A/149/20/L

6 Longback Cottages Arundel Road ANGMERING BN16 4JT

Part two storey part single storey rear extension

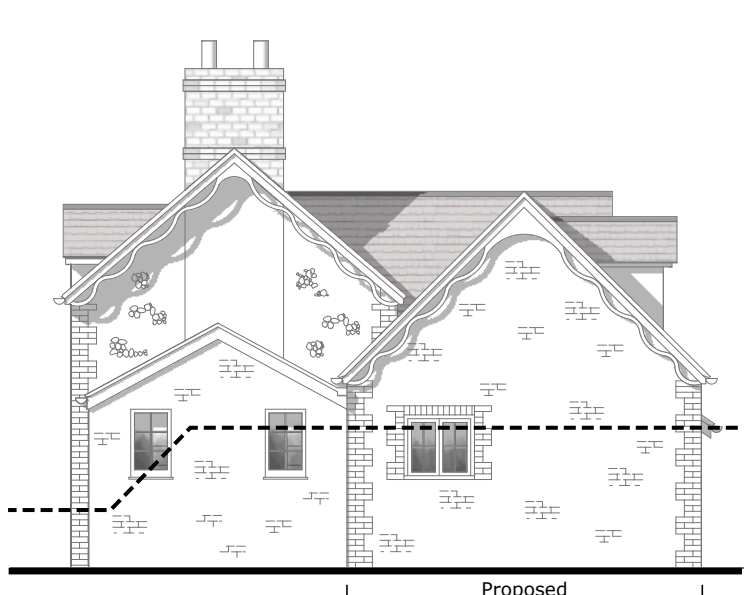
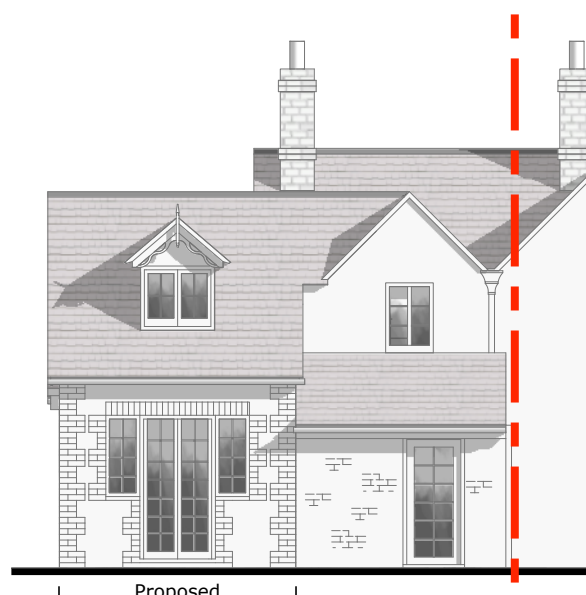
The proposal is for an extension to one of the end of terrace properties. It would appear that the property has already been altered and extended, and the proposal would be located behind a small-scale single storey side extension. Such a proposal represents a large extension in the context of the very modest residential cottage, especially when viewed from the north and west and would be out of character. Further, it is thought that the extension could be partly viewed from the road when travelling into the village, and therefore visible to the conservation area.

It is noted that the intention is to use materials appropriate for the building so as to ensure that it is of suitable appearance. Such an approach is supported, subject to them being provided to the council by way of condition.

The proposal is such that the impact can be described as causing less than substantial harm in accordance with paragraph 196 of the NPPF (2018). As such, you will also need to consider the public benefits that the development may achieve as part of your assessment of the application, along with the contents of the Planning (Listed Buildings and Conservation Areas) Act 1990 (as amended).
